HAMPTON PARK, LITTLEHAMPTON

TRAFFIC IMPACT OF ADDITIONAL 100 DWELLINGS ON LOCAL HIGHWAY

Technical Note Addendum

Persimmon Homes

FITZALAN LINK
STAGE 2

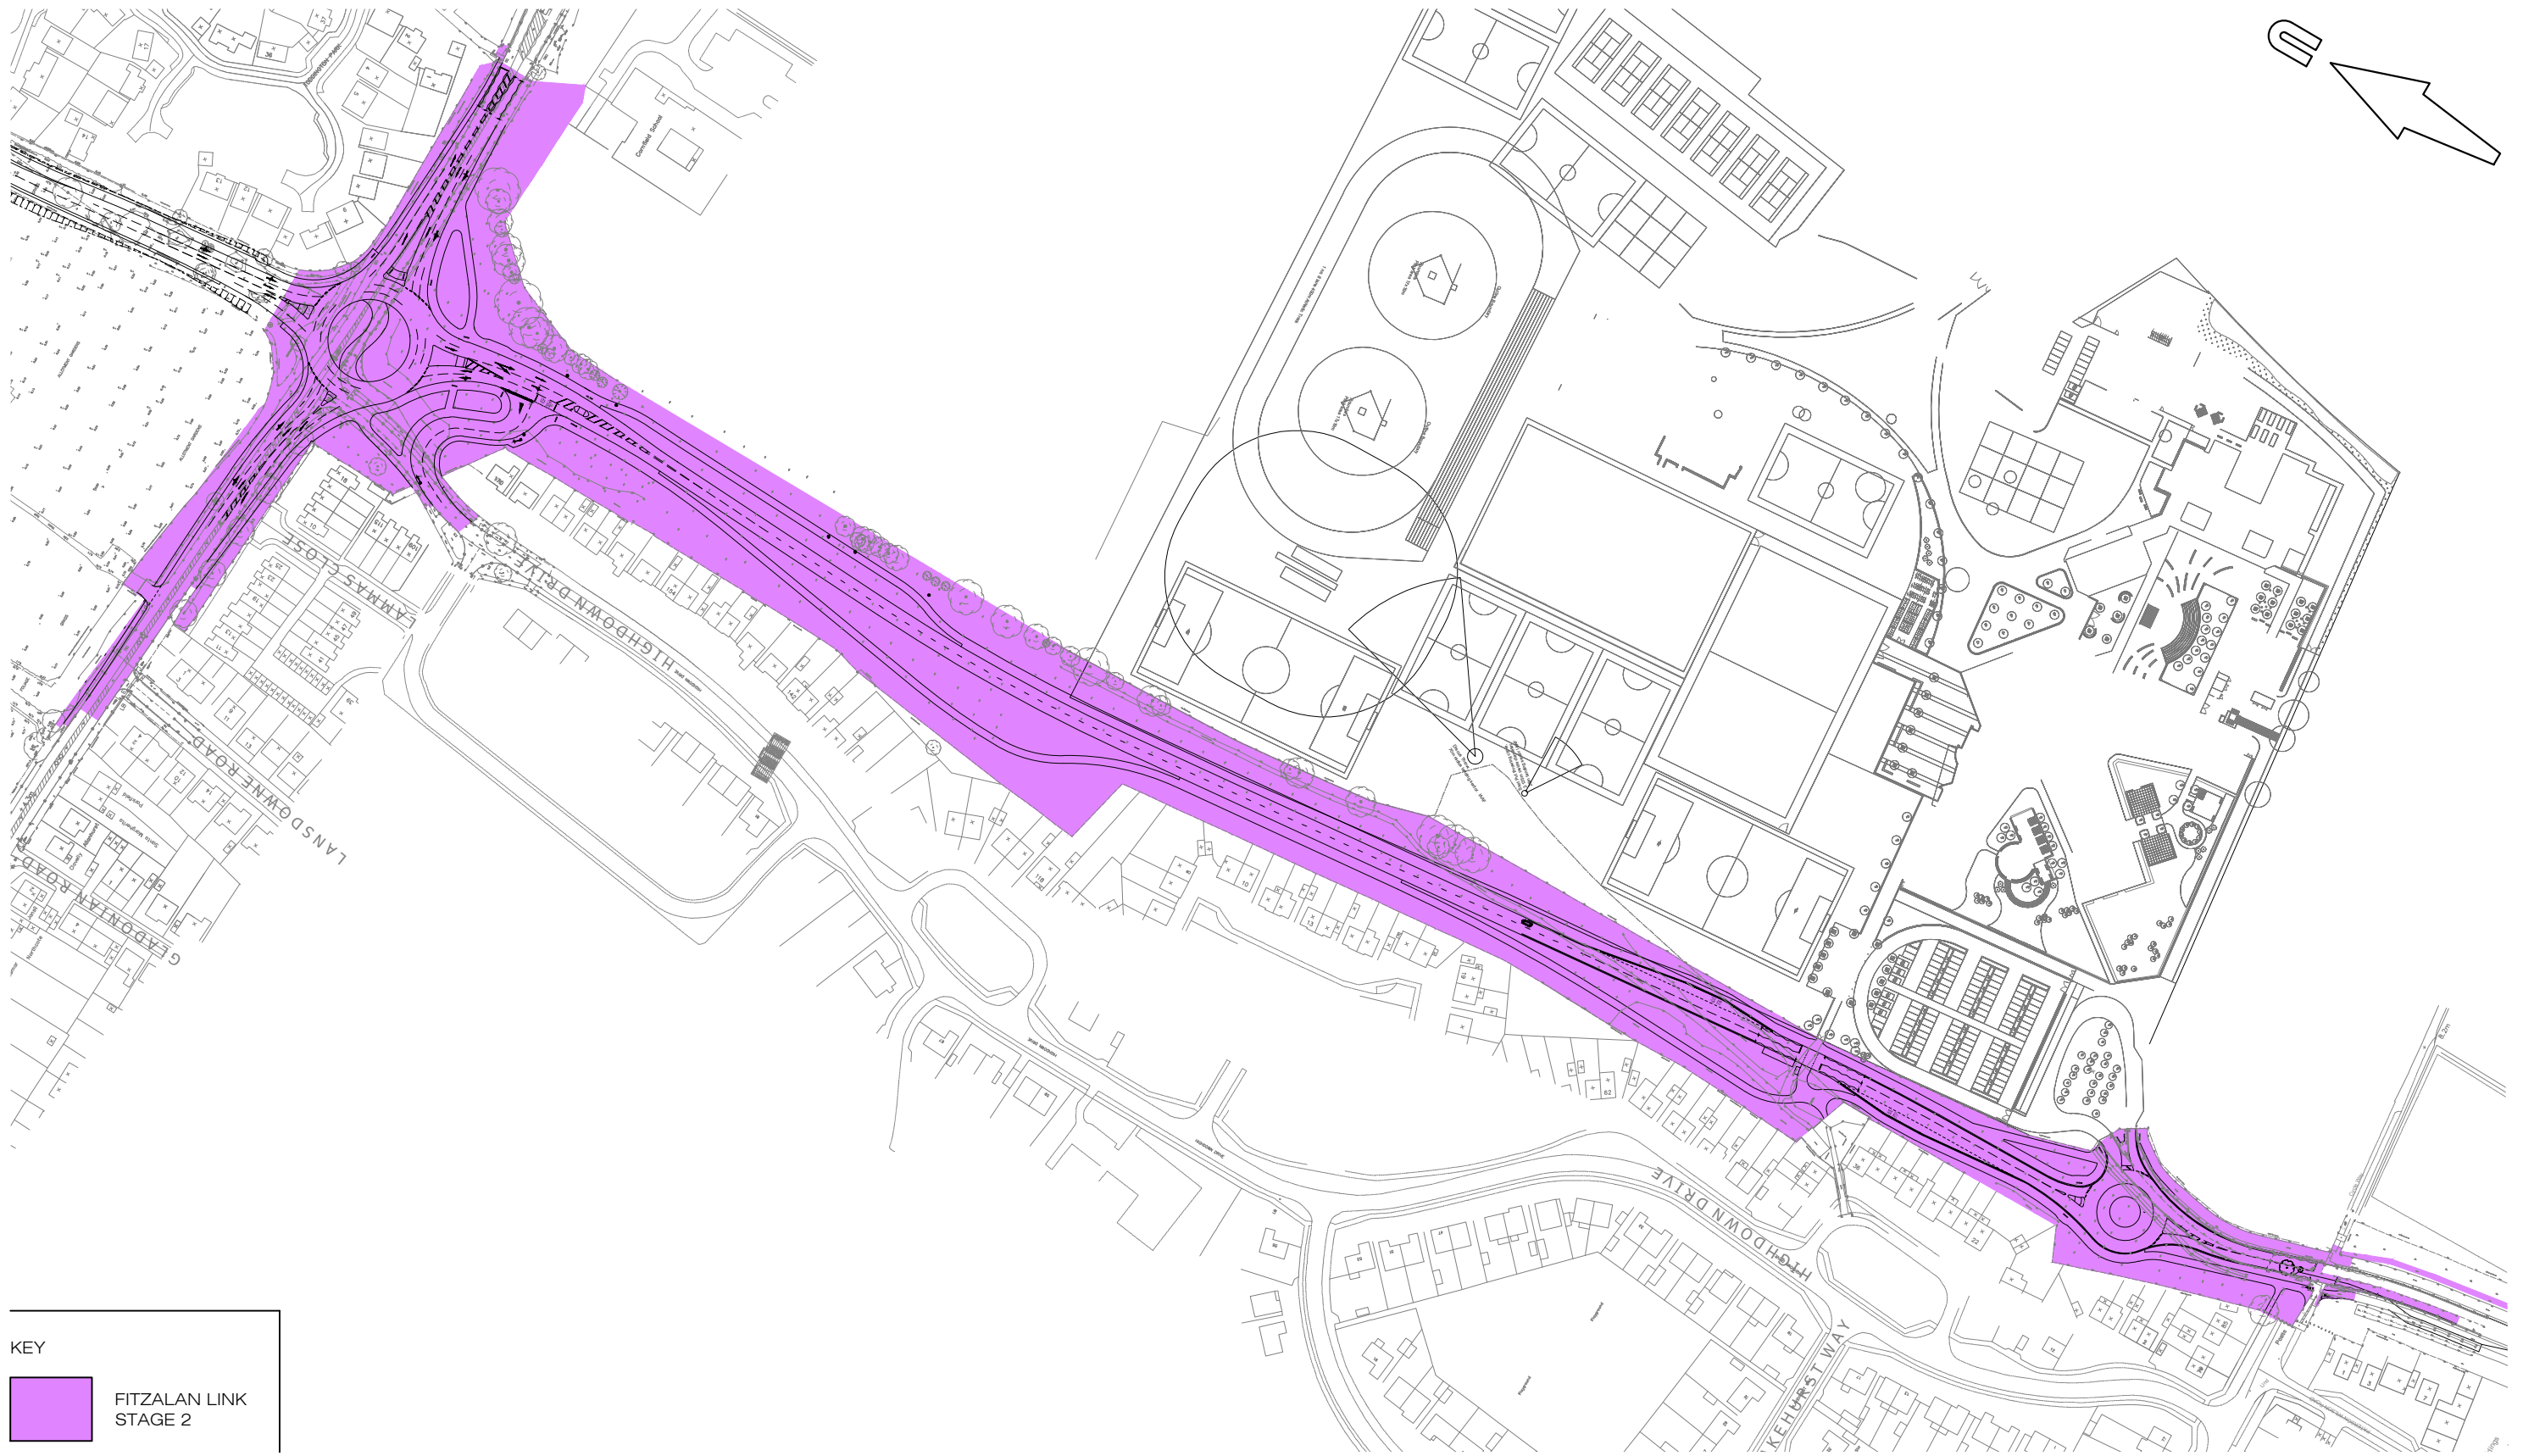
- iv. *How does the Fitzalan Link Road fit-into the proposal as it is due to be completed by the 400th dwelling and relies on the delivery of the RBT at the southern-end of the Southern By-Pass (the latter due to be delivered as part of the SBP works)?*

2.4.2 Bright Plan have been advised that the works on the bypass, including the Fitzalan Link, recommenced on the 22nd June and the Fitzalan Link (plus the southern roundabout) will be completed by the 400th occupation.
